Our Ref: A/121/15/PL
Your Ref:

Town & Country Planning Act 1990 (as amended)
Town and Country Planning (Development Management Procedure) (England) Order 2015
Application for Planning Permission

Development Demolition of existing stables & storage buildings & erection of 2 No. two bedroom holiday cottages & barn & associated sand school.

Location Herons Farm Dappers Lane Angmering

Proposed Block Plan

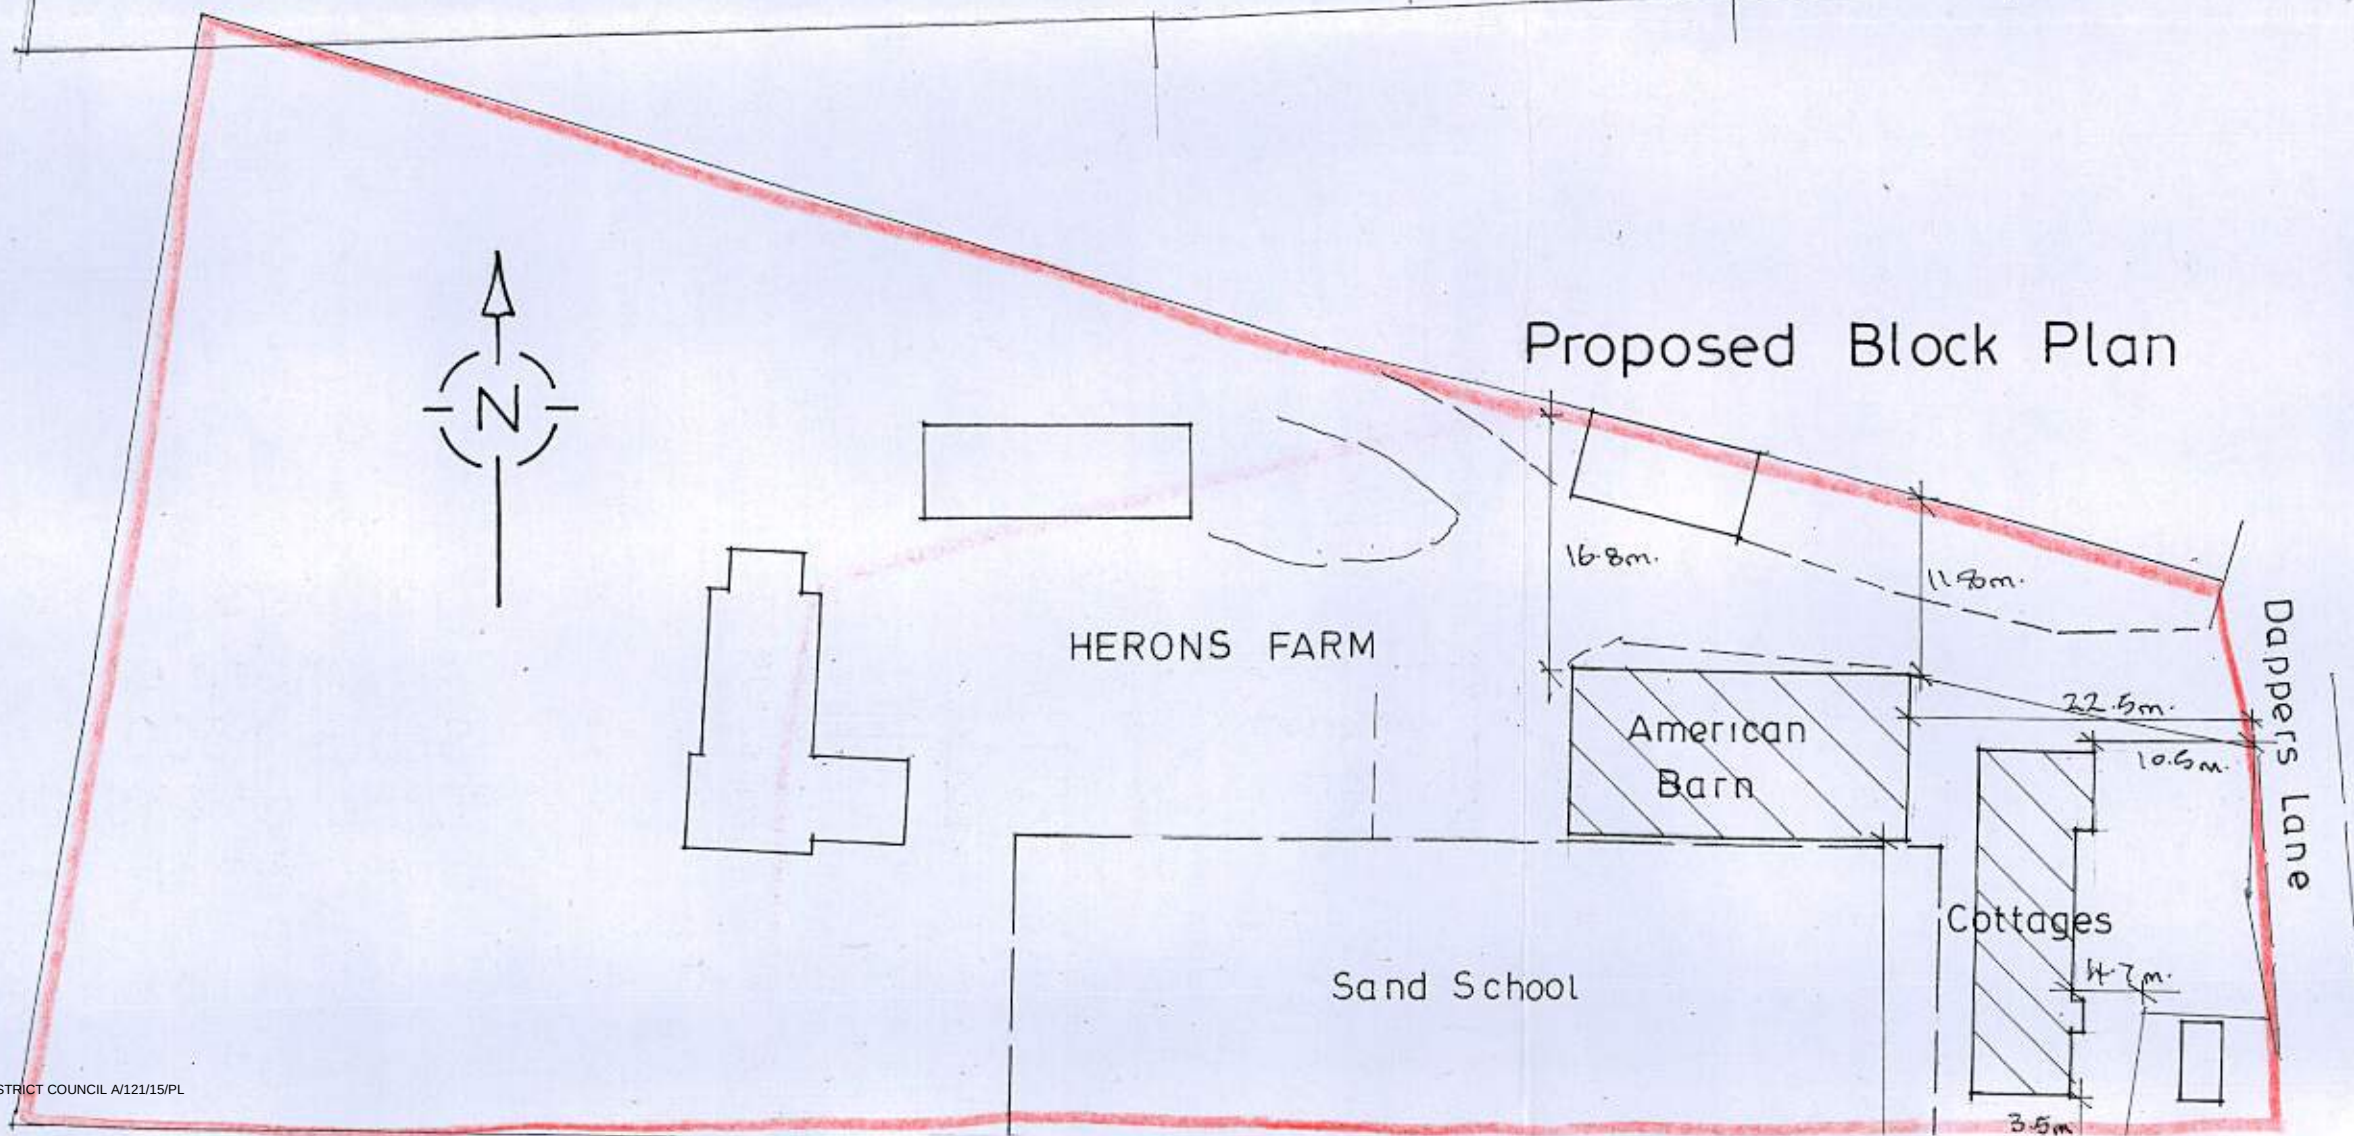
Block Plan

Please provide measurements from the proposed barn and holiday cottages to the site boundaries.
